Response to consultee comments made on planning application for food outlet at former Swan public house, Station Road, Marsden.

Conservation and Design.

Proposed front elevation (1:100)

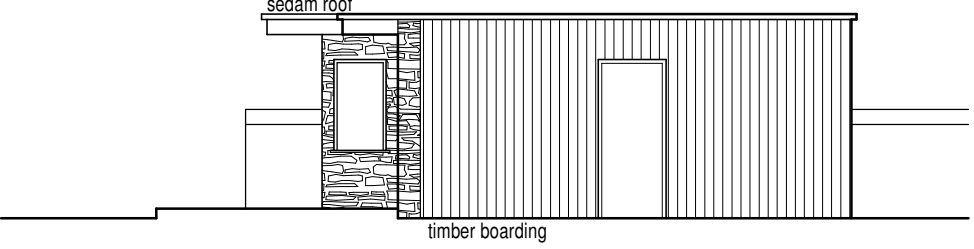
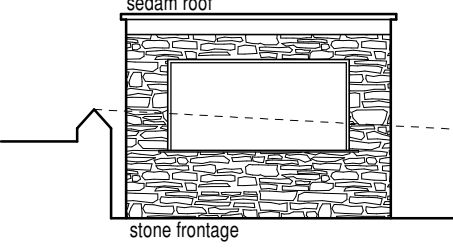
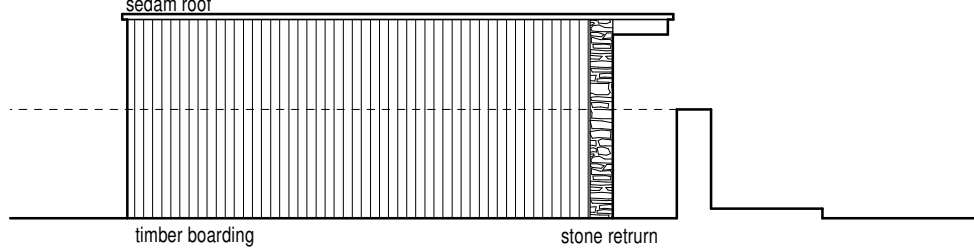
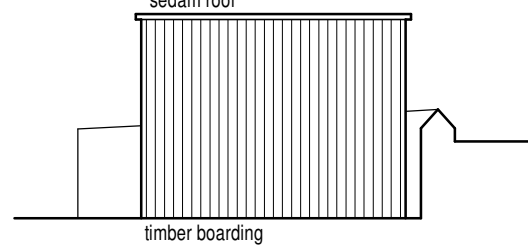
Comment is made about the proposal obscuring the streetscape view of the existing stone gable of the adjacent property. Two options (traditional and modern) have been superimposed onto a photograph of the gable end which demonstrates that this will not actually be the case.

Proposed site plan (1:100)

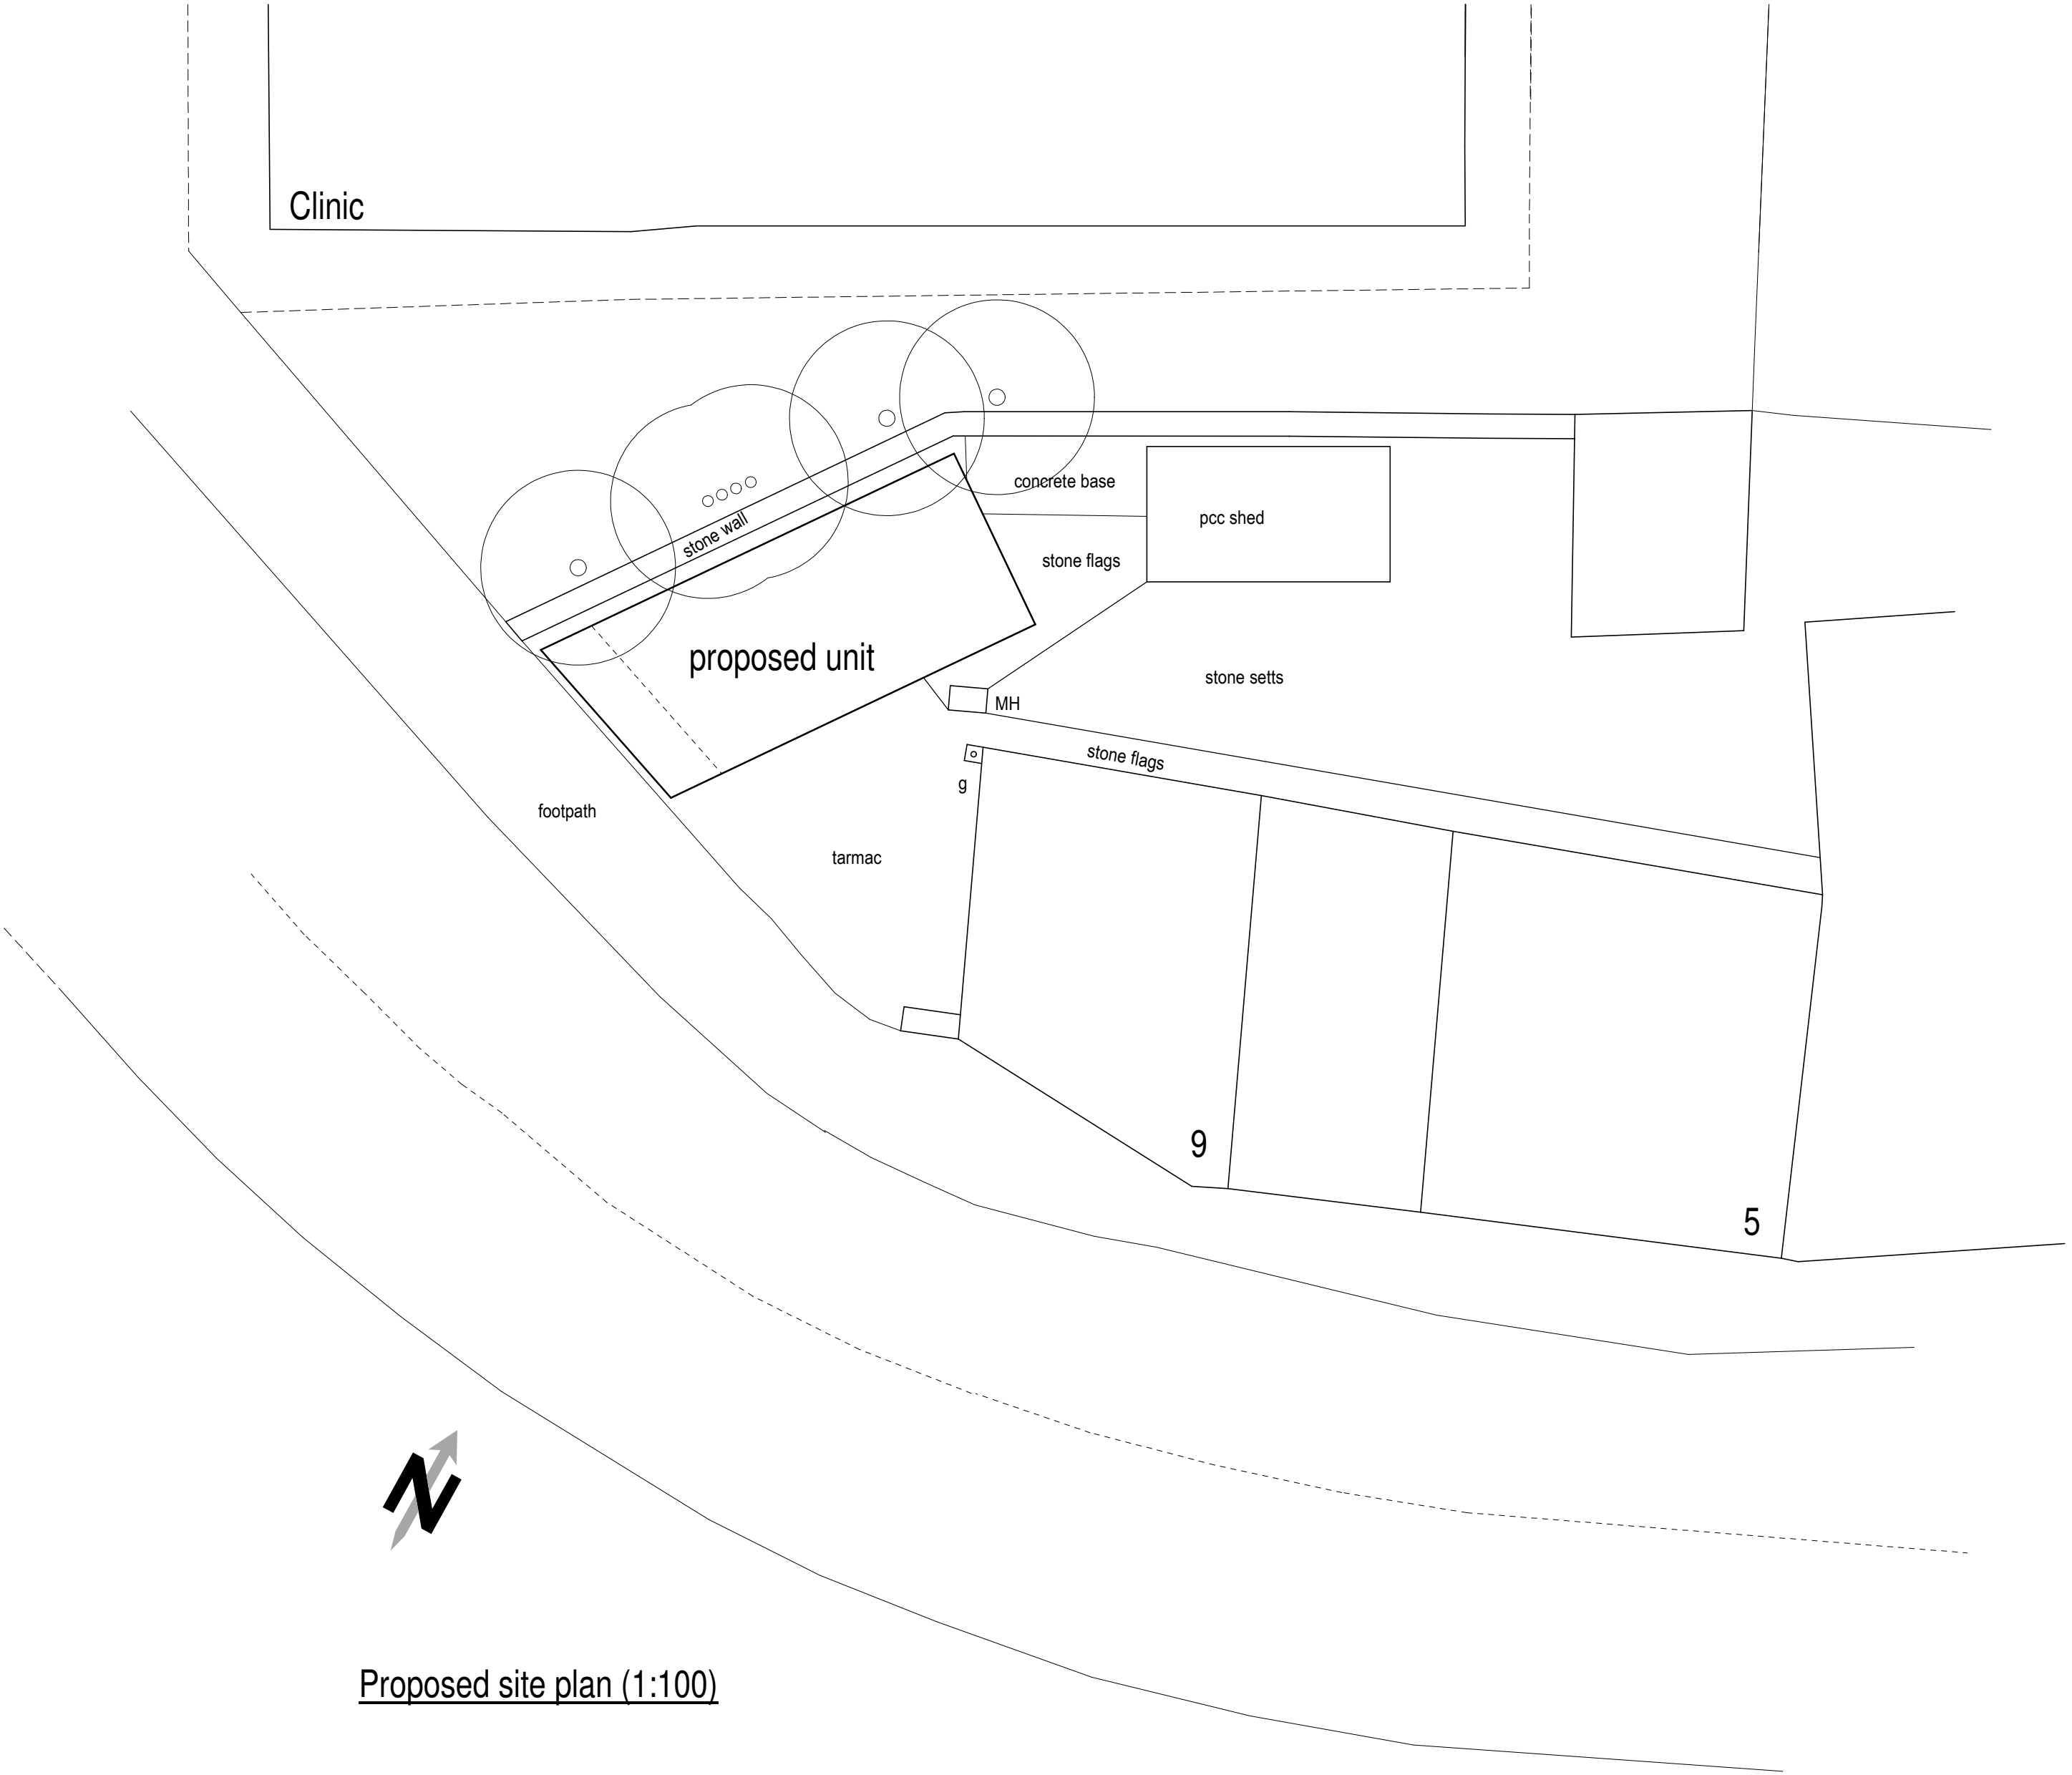
- How the unit will be serviced – The unit will be serviced from the roadside, which is the same method as the public house did for all the years it was in operation. The 'yard' where the proposed unit sits was previously used as the beer garden so did not provide either access to the rear or any contribution towards servicing of the premises. Access to the rear of the building and bins will still be achieved once the new building is constructed.

- Storage – This will be within the new building.
- Disposal of refuse – A bin store will be provided as shown on the attached site plan.
- Means of lighting – There will be no external lighting.
